CITY OF ALBUQUERQUE

RE: **Oso Bio Syringe Line**
Grading Plan for Building Permit 4401 Alexander Blvd
Engineer's Stamp Date 6/21/2018 Disapproved
Hydrology File: F16D003B1

Based on the information provided in the submittal received on 6/21/2018 the above-referenced Grading Plan still does not adequately address the "Plan Check Comments" 3, 4, 5, 6, 7, 9, & 11 on the conditionally approved Grading Plan with engineer's stamp 8/29/2017 (see attached). The building permit was issued in August 2017 with the understanding that all of the conditions would be fulfilled prior to Certificate of Occupancy. DCI engineering made two additional submittals which were reviewed in December 2017 and February 2018, and this application from BHI makes the 3rd submittal since the conditions were agreed to by Oso Bio at the time the building permit was first issued.

SECTION A-A: POND OUTLET DETAIL
N.T.S.

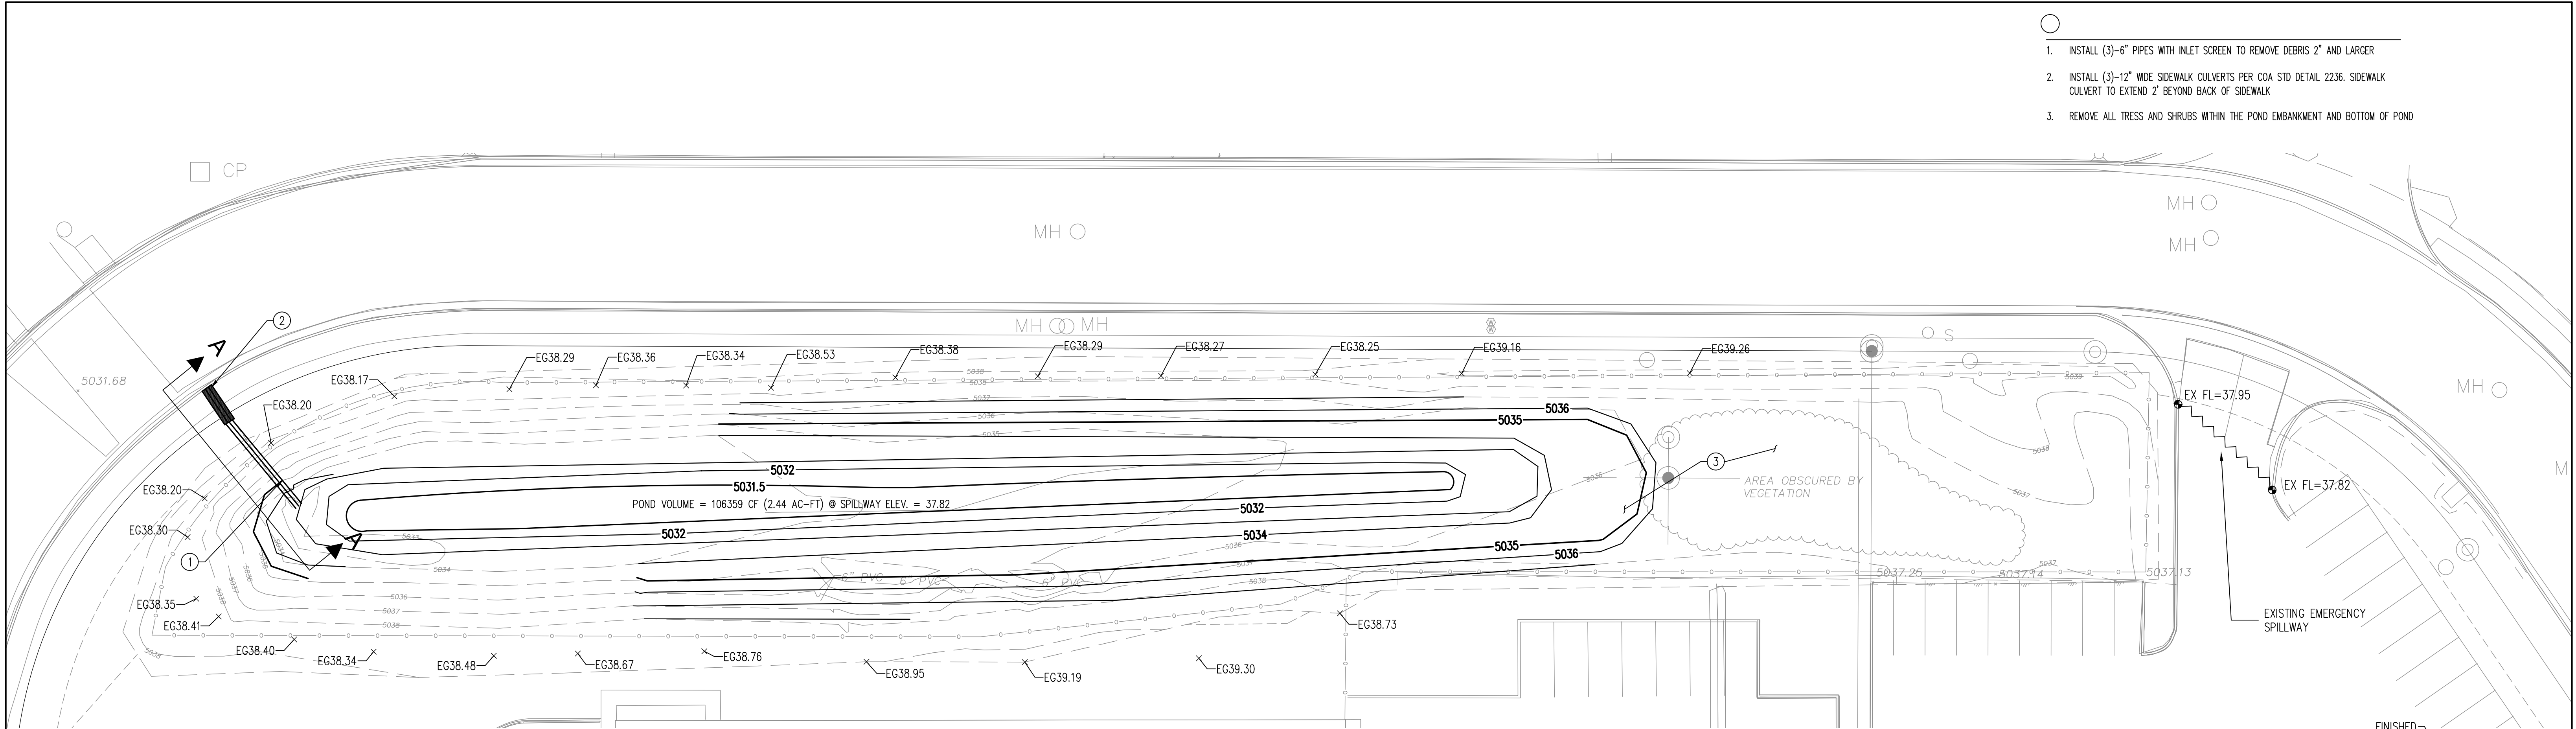
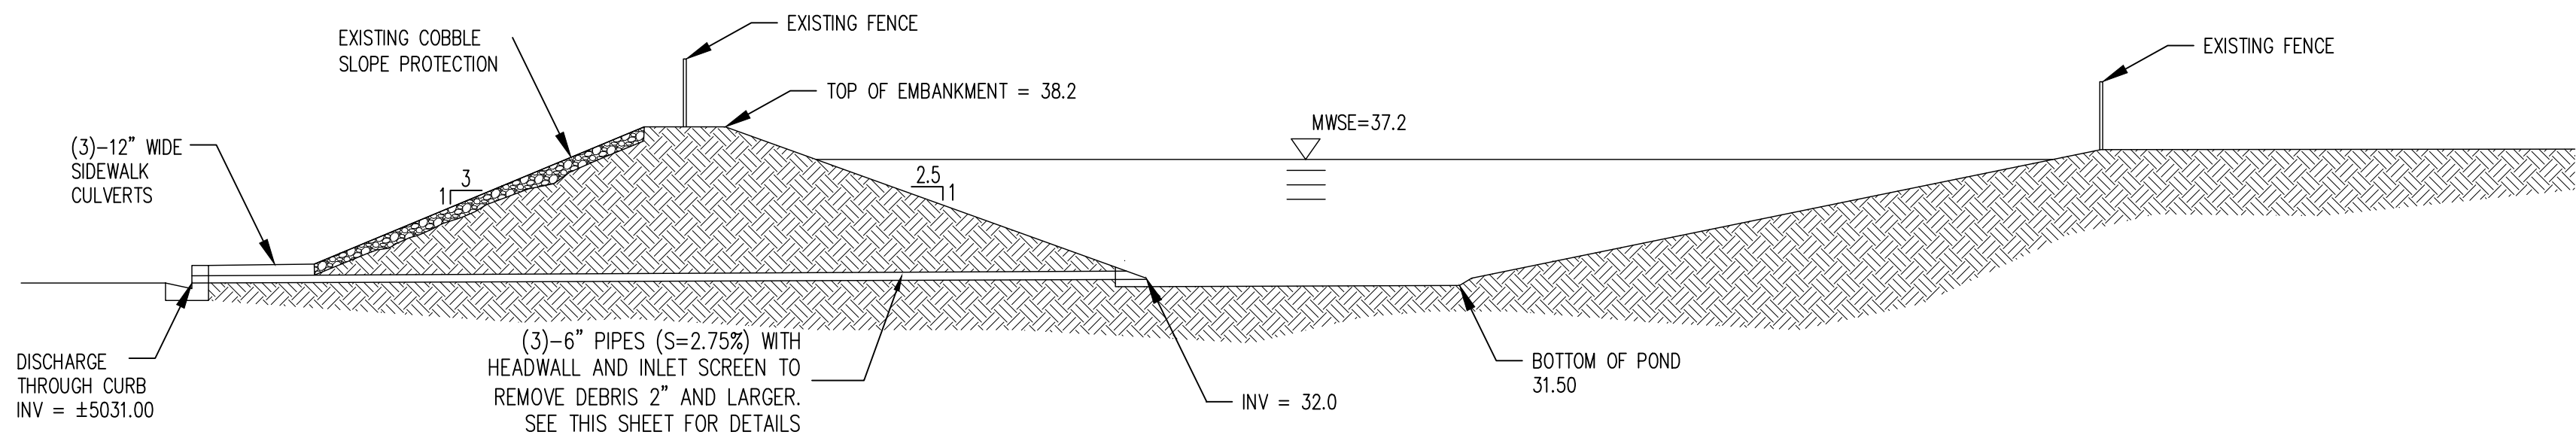
- d. Updated site layout of the Building expansion and associated grading.
2. All calculations must be presented including the newly measured pond topography and volume calculations, the outfall structure details and hydraulic calculations, and hydrology calculations in accordance with the DPM. The SCS method is not allowed in the current DPM though it is allowed in the draft revisions to the DPM. Composite CN calculations are required using the approved curve numbers in the draft DPM

3. First flush is required for redevelopment projects like this, and the conditions of approval on the 8/29/2017 plan were made assuming that the existing pond already serves that purpose in addition to providing the stormwater management required for all sites in the Renaissance Center. The pond design must demonstrate compliance with both the first flush and stormwater management requirements, and the approved pond design must be clearly shown on Exhibit 'A' to the drainage covenant with the design volumes and outlet structure size clearly labeled. The exhibit may be on several sheets. The drainage covenant must be signed by the "owner" of the property that the pond is located on, Tract A. If a separate agreement between the two property owners, Tract A and Tract B, is required by the owner of Tract A, the City does not need to be a party to that agreement. The owner's signatures must be notarized and the original document together with a \$25 check payable to the Bernalillo County must be submitted to Madeline Carruthers on the 4th floor.
